Application No: FP/54/26/AG
Site Address: Rabbit Island Rear of 84 Brooks Lane Bognor Regis PO22 8DN
Description of works: Prior approval under Schedule 2, Part 6, Class A for the creation of a new agricultural track.

Thank you for your internet representation made on 20th May 2026 which has been recorded as an objection with the comments as follows:

Revision:			
address Lands off Brooks Lane Felpham, Felpham, Bognor, PO22 8DN			
project Proposed track			
title Existing Location Plan			
scale 1:1250 on A3	date Dec 2025	dwg no. 2025.485.01	revision

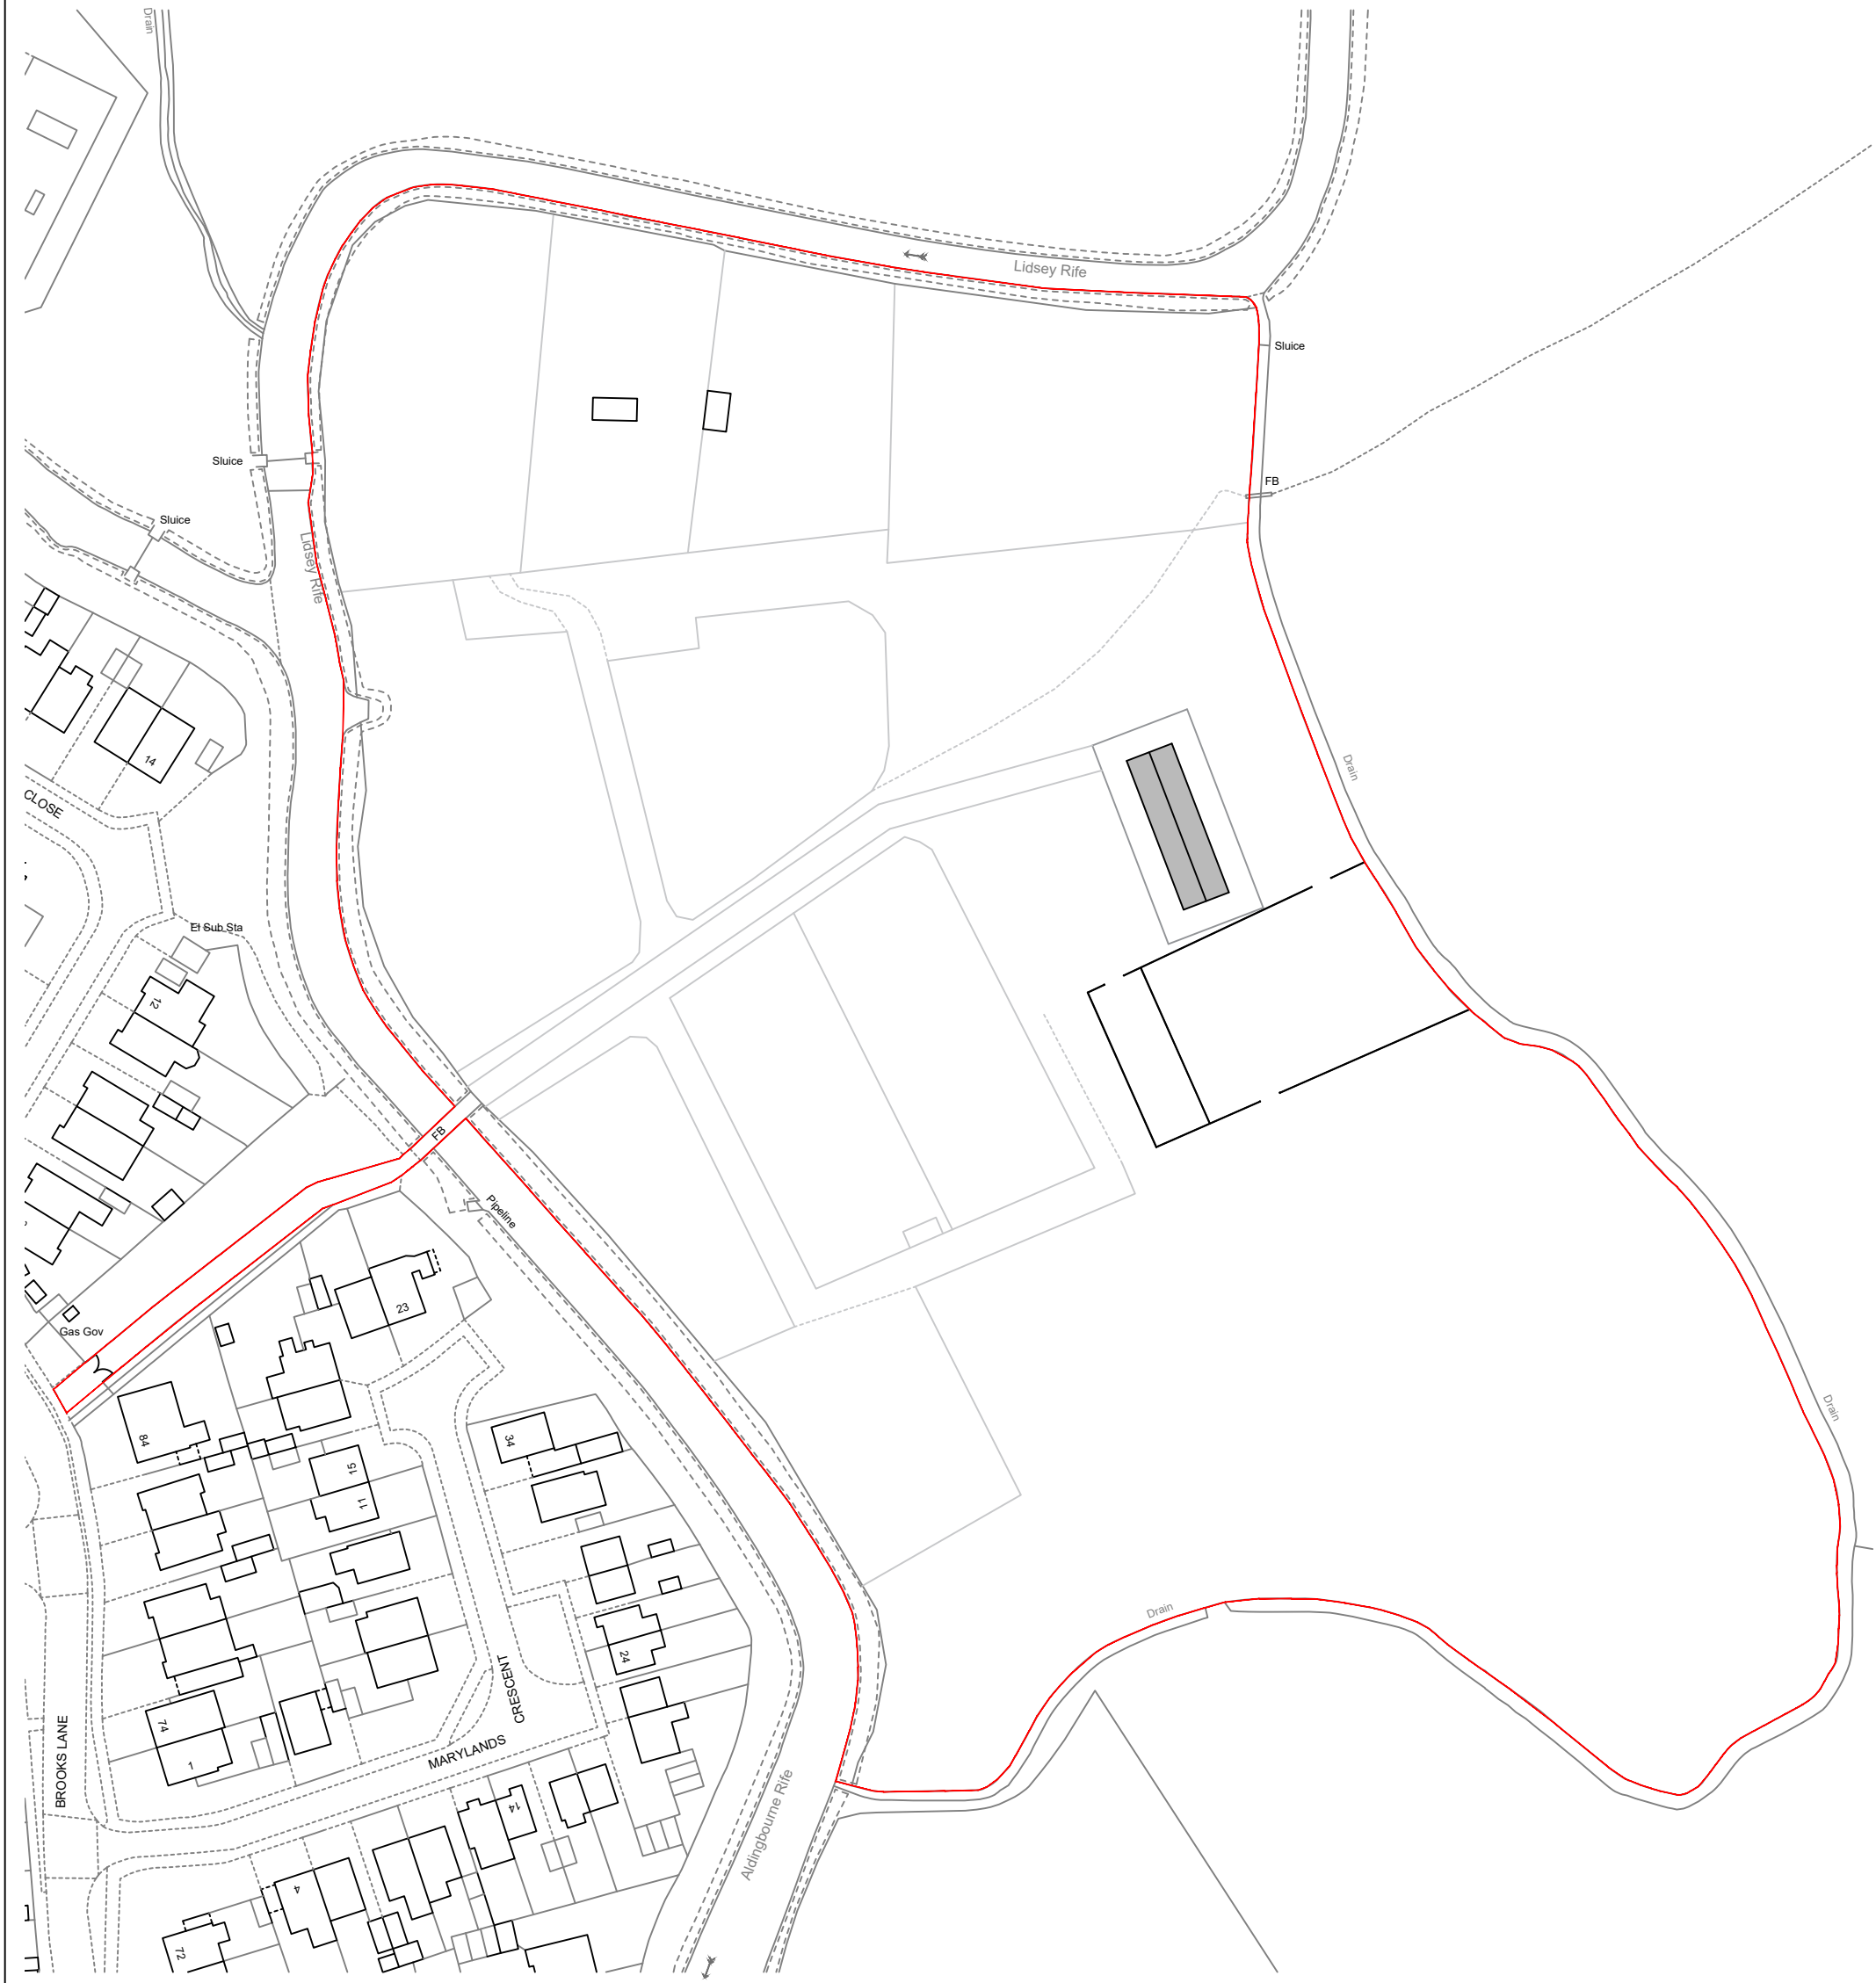
OBJECT, a recognised PROW is not included in the application and proposed, identified as agricultural track, will serve a building already deemed in contravention of planning and currently unauthorised
